AB/120/20/PL & AB/121/20/L

Old Bank House 1 High Street Arundel BN18 9AD

Change of use of existing building from office (Use Class B1a) to residential dwelling (Use Class C3) with minor internal layout changes. This application affects the setting of listed buildings, affects the character & appearance of the Arundel Conservation Area

| Title:-      | Proposed Floor Plans                                      |

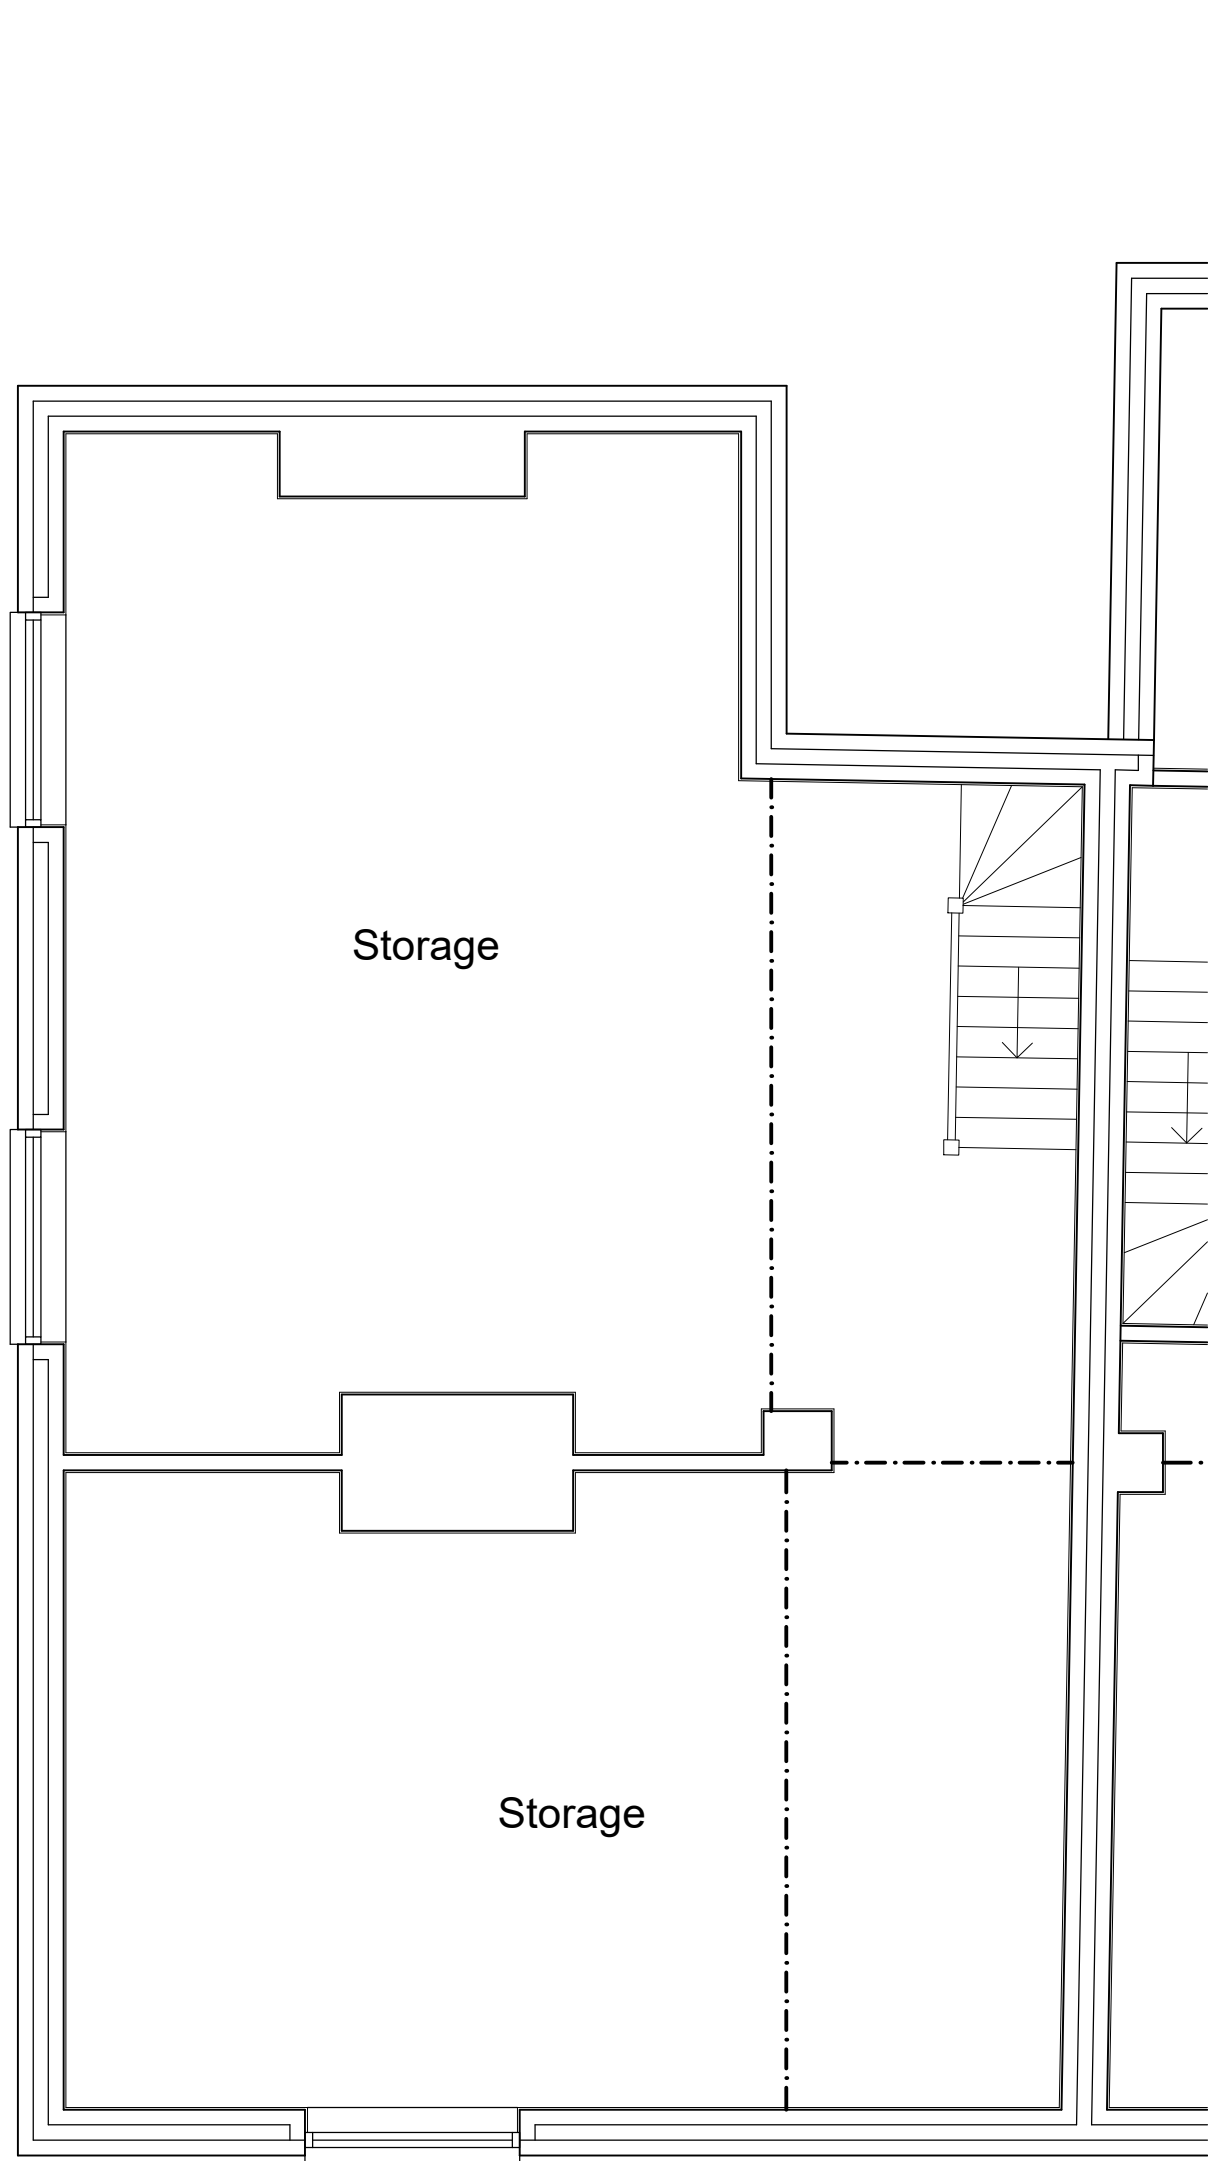
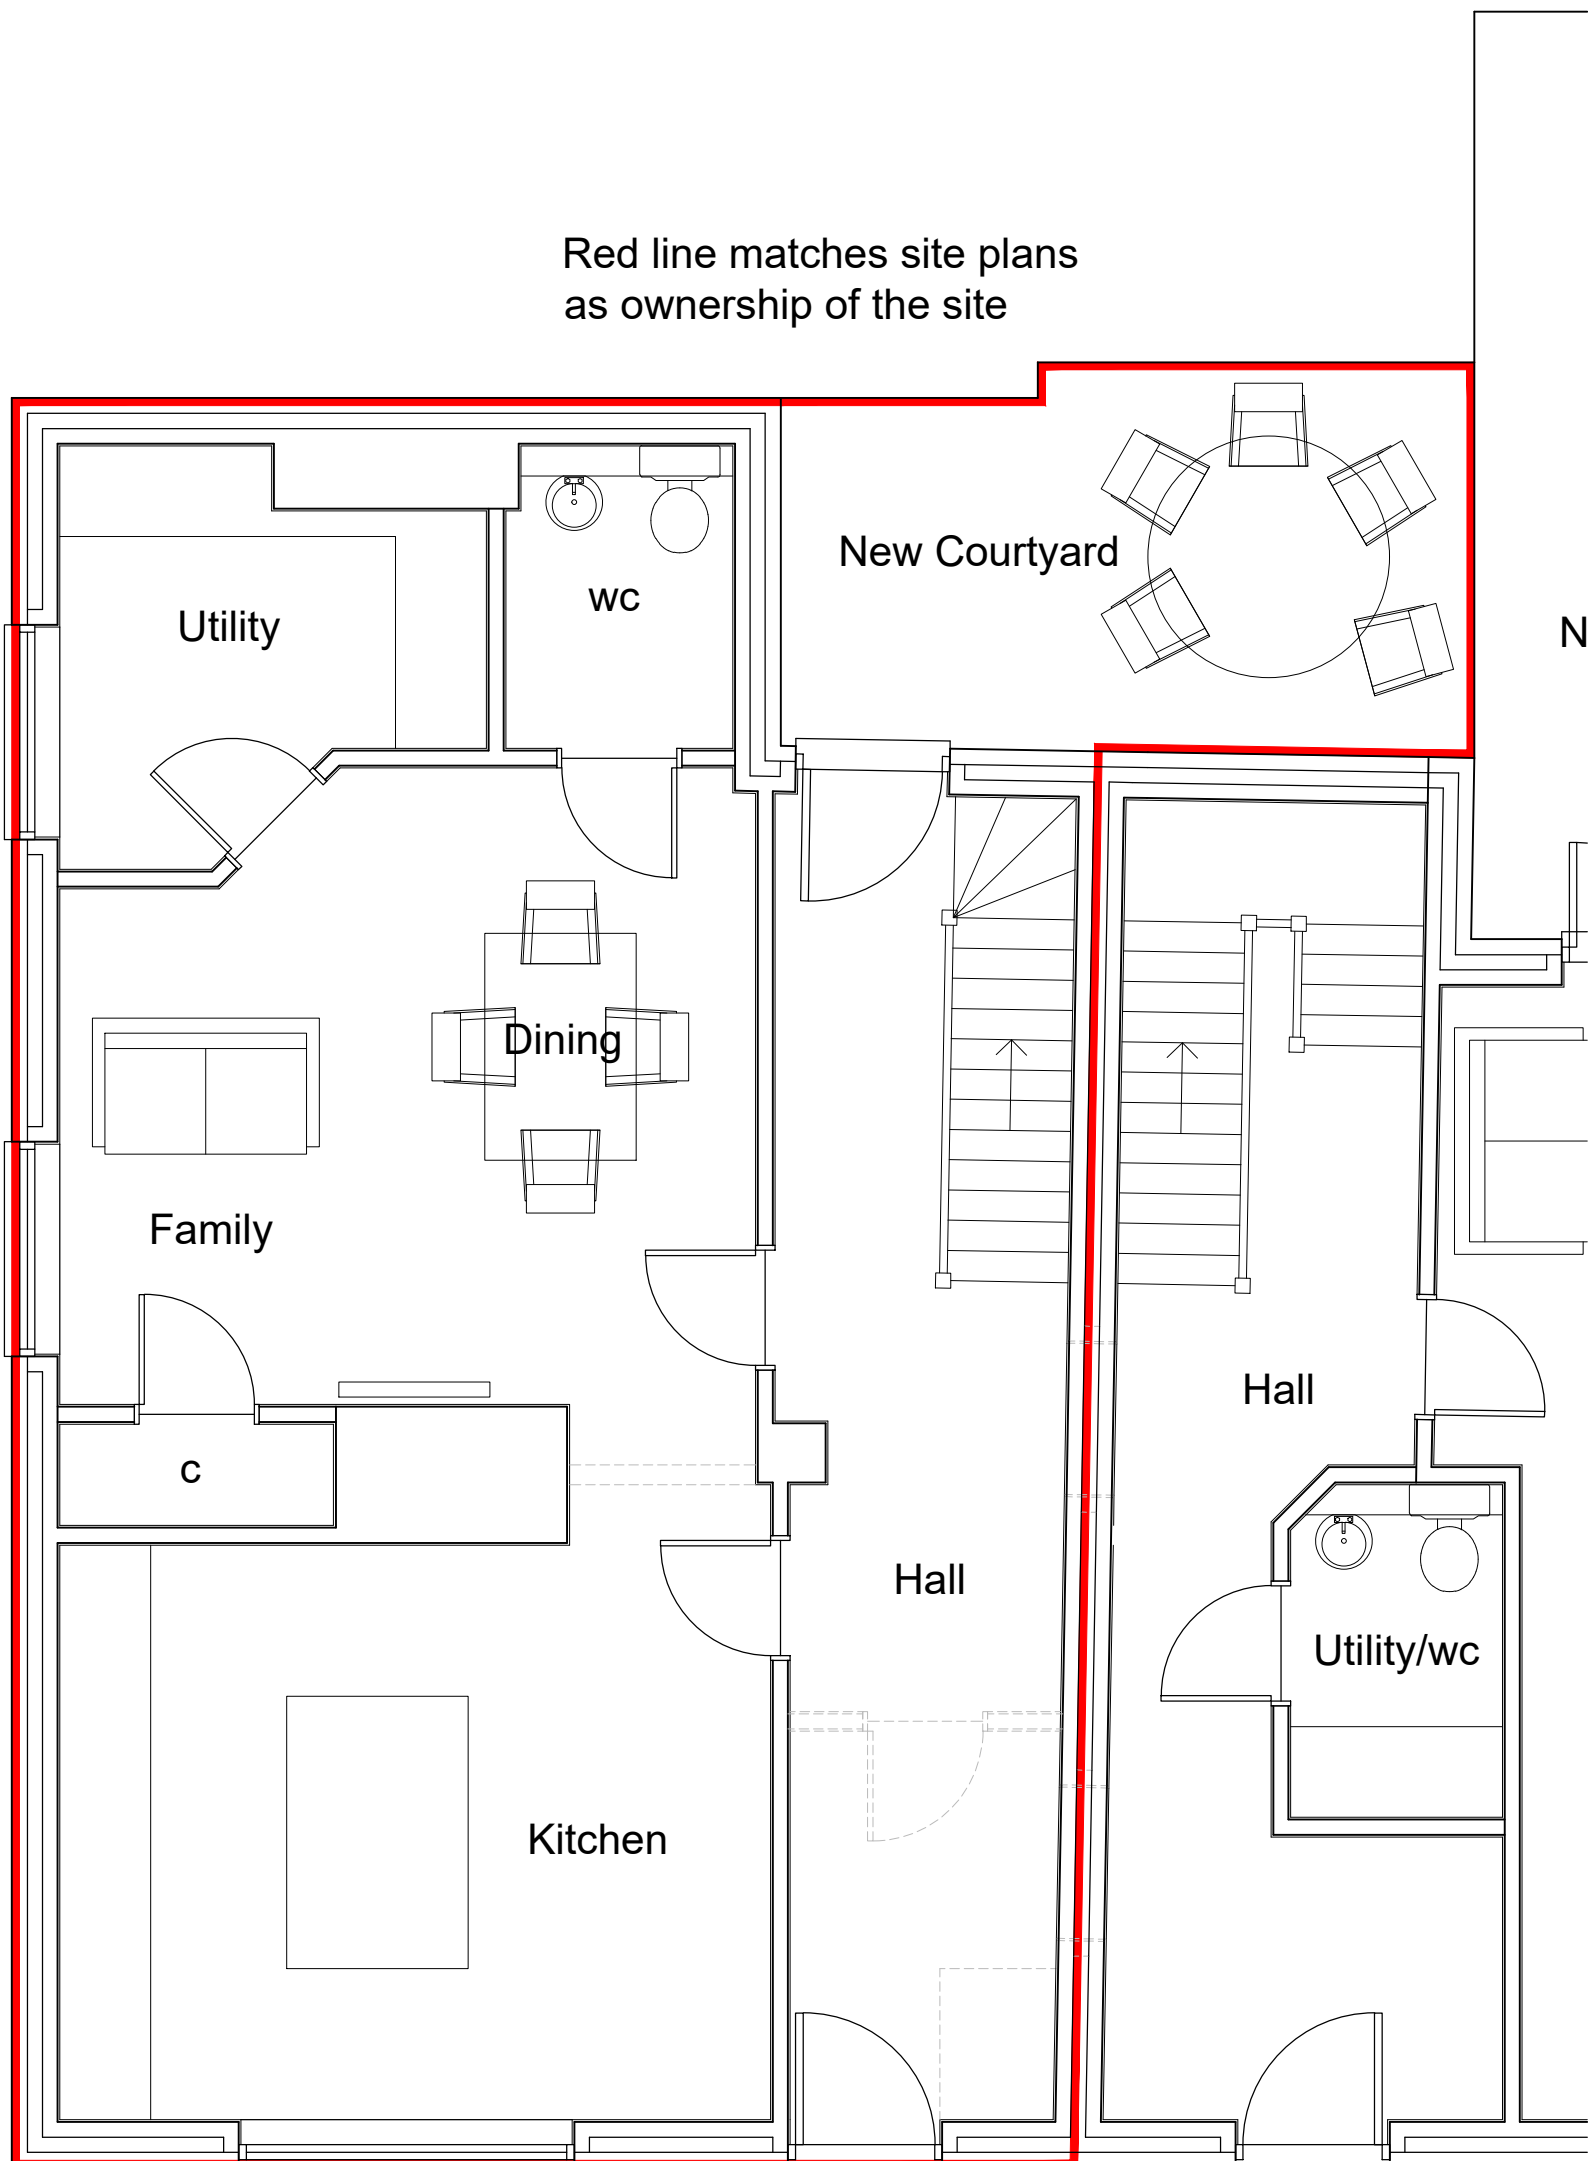
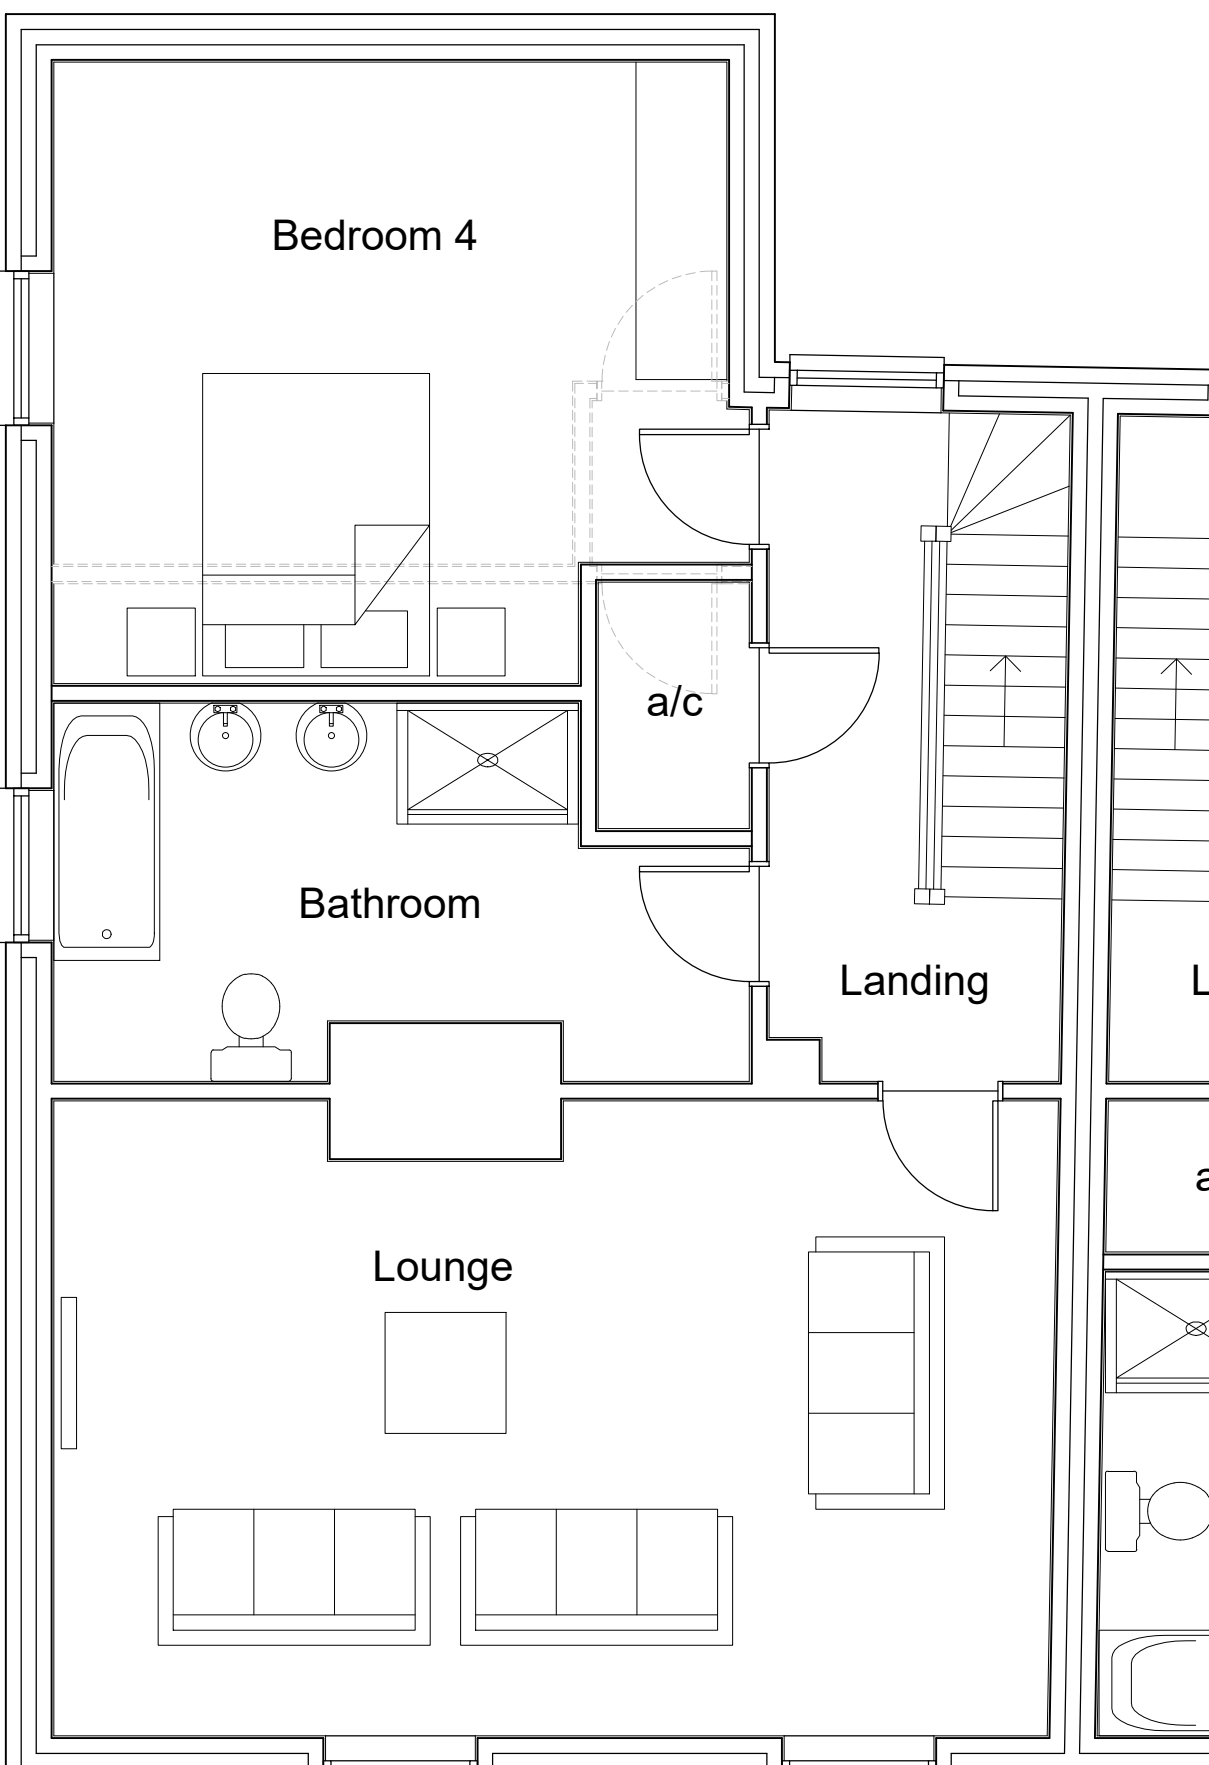
When reviewing the plans provided it is clear that a number of internal alterations are required including the relocation of walling and the introduction of new kitchen and bathroom facilities. Reference is also made to the fact that there has been a considerable amount of modernisation to the interior of the building, including the introduction of fire doors. It is not clear if these fire doors are to be replaced, and if they are, what with? The loss of modern material is acceptable, especially if it is to be replaced with something more in keeping with the age and style of the building. Details of the internal joinery such as doors and skirting boards etc. could be provided for by way of condition, if you are minded to approve the application. The relocation of some internal walls are of a scale which will not harm the significance of the building.

The introduction of new bathrooms and kitchen would be into rooms currently used as offices and will require the introduction of new plumbing/electrics into these spaces. It is not clear how the drainage will be dealt with from these new rooms. It should not be via the elevations which present themselves to the public domain. Likewise, care must be taken when installing new pipework and cables so that limited historic fabric is lost.
